Request for Responses – Section 8

8.2 Derby Climate Coalition - Are the claimed economic benefits of the scheme are sufficiently supported by evidence from comparable road improvement schemes, having regard to the concerns expressed [REP6-030] and the documents appended to it?

Request for responses – Section 9

Development Consent Order Number	TR010022
Drawing Title	FIGURE 8.14 AMPHIBIAN BASELINE SUMMARY LITTLE EATON JUNCTION

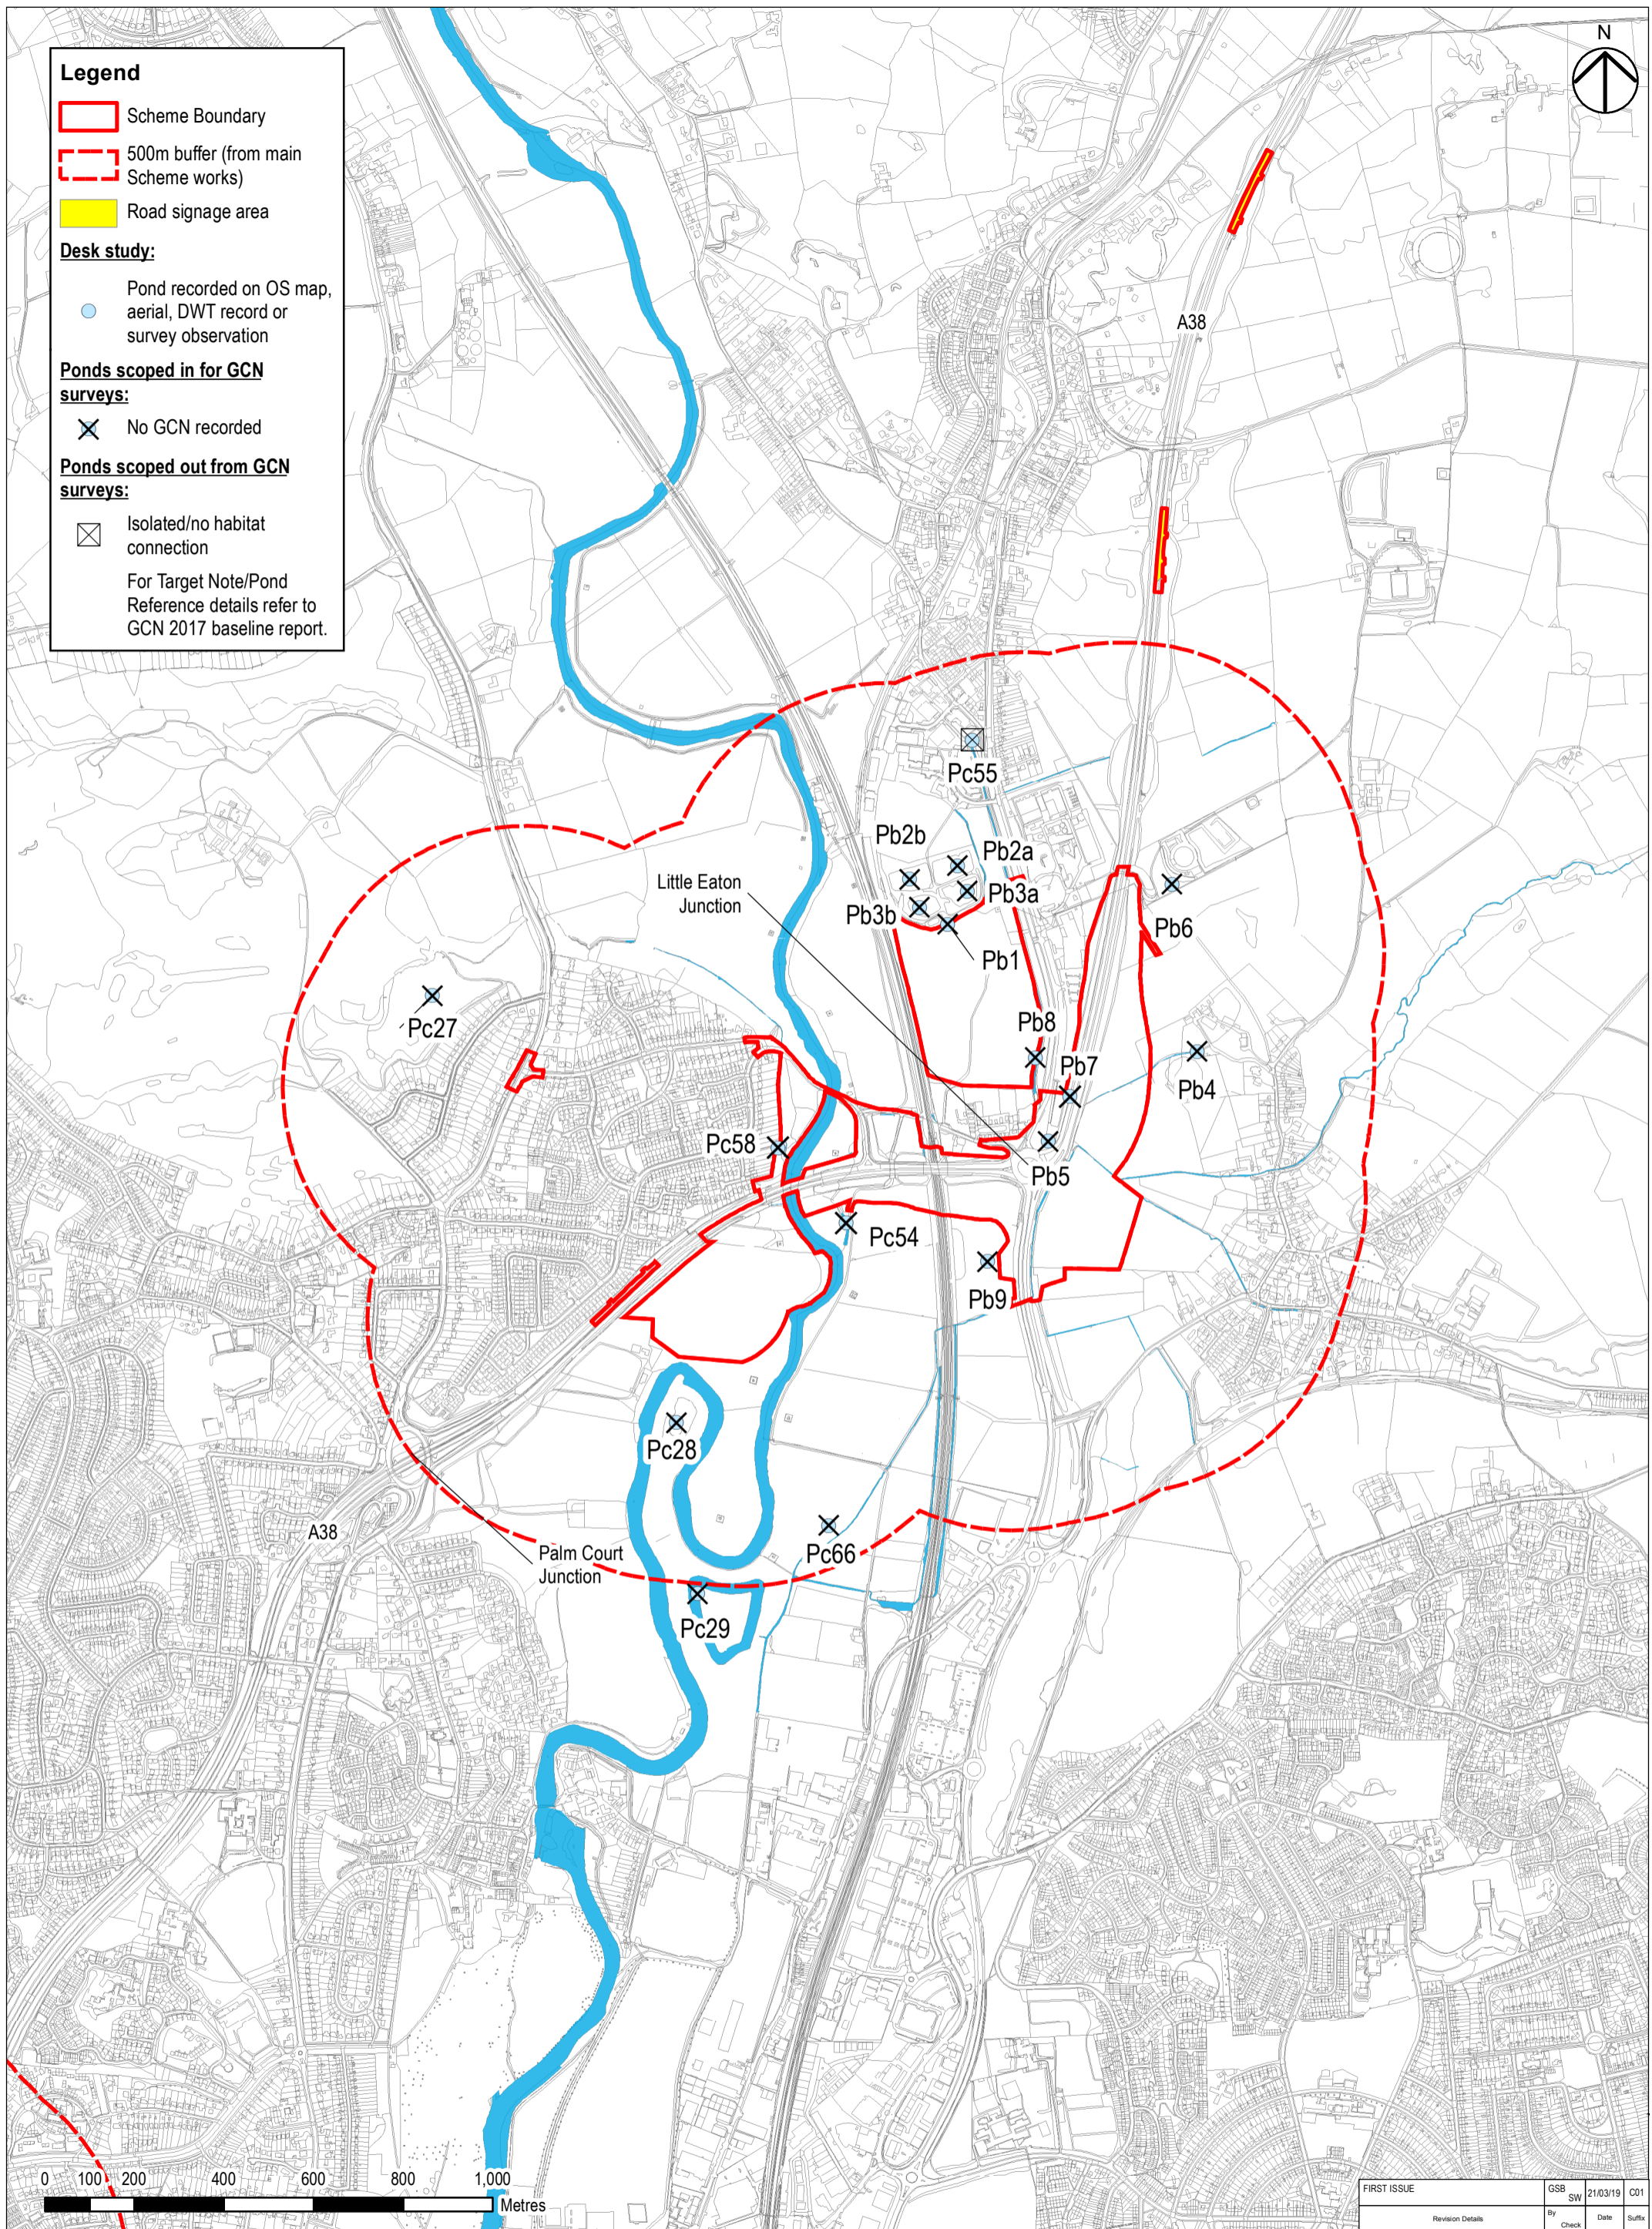
- **Great crested newts are known to be found in an area just outside the 500m buffer zone – an area that was thought important enough to warrant a special survey**

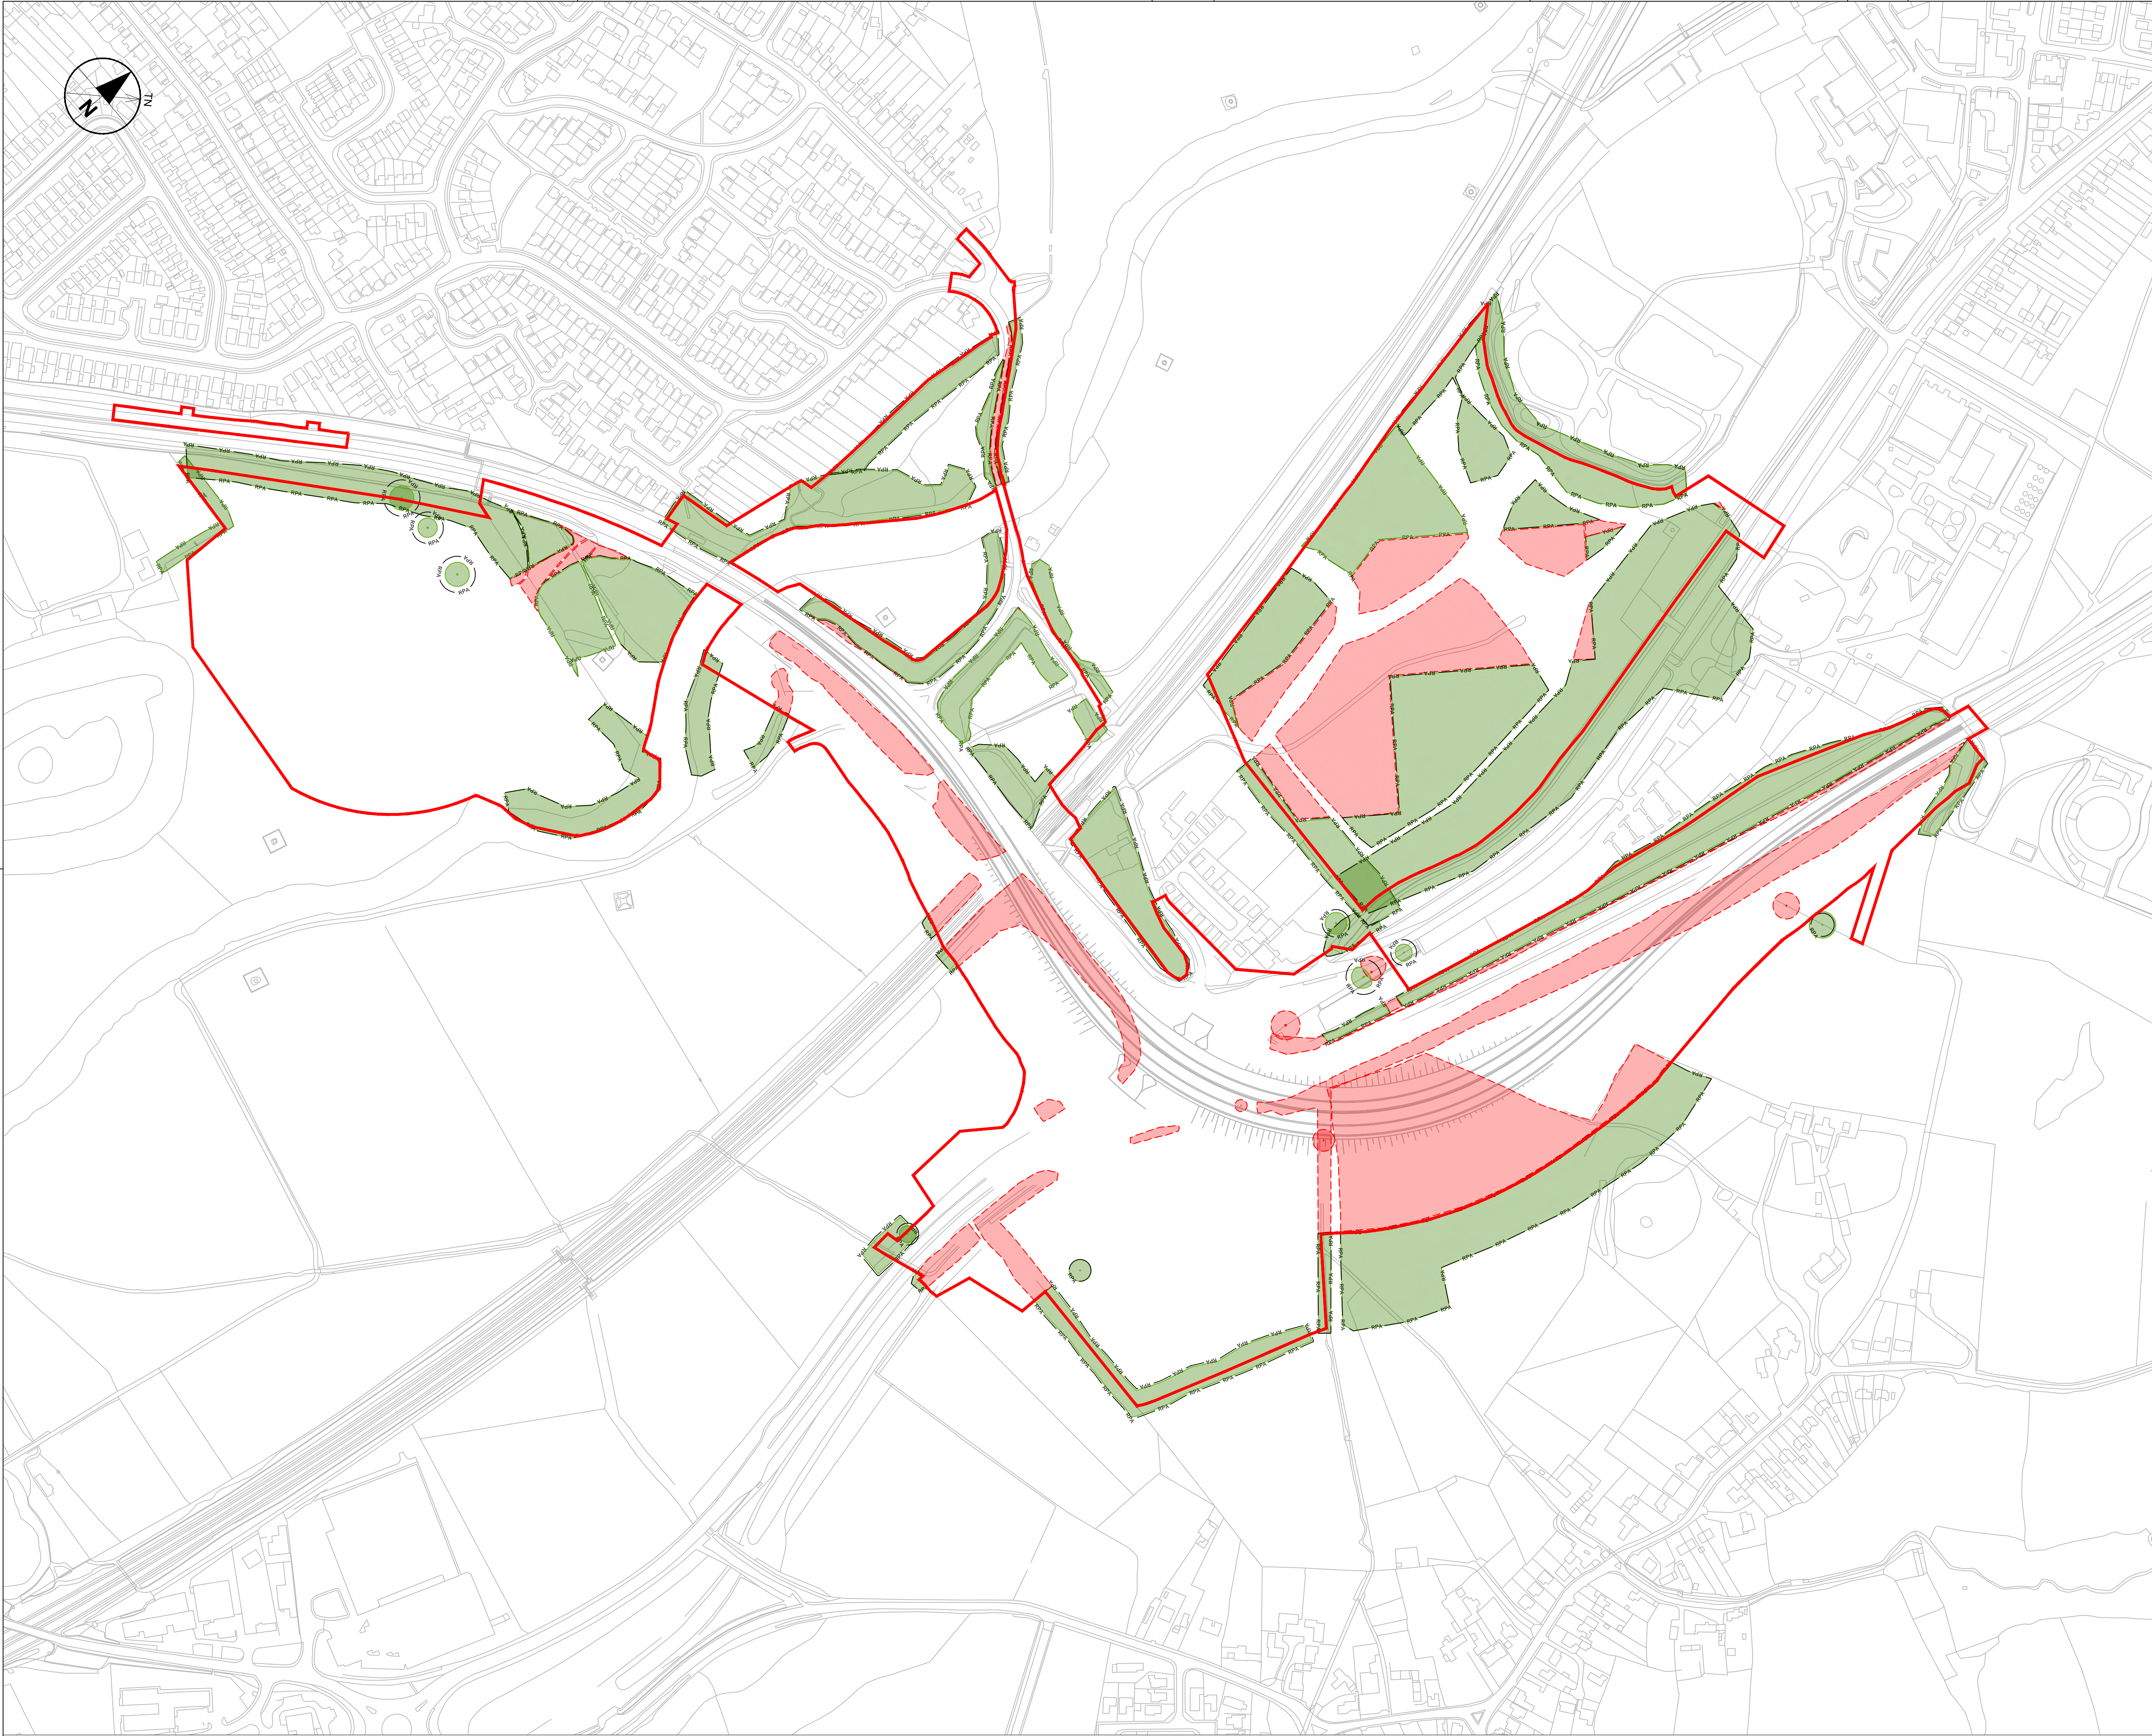
- **Last time Little Eaton Roundabout was modified there were significant delays due to the presence of White clawed Crayfish**
- **The Woodland Trust are concerned about the felling of a veteran oak – T358 and point out that the National Planning Policy Framework states: “*development resulting in the loss or deterioration of irreplaceable habitats (such as ancient woodland and ancient or veteran trees) should be refused, unless there are wholly exceptional reasons*”.**
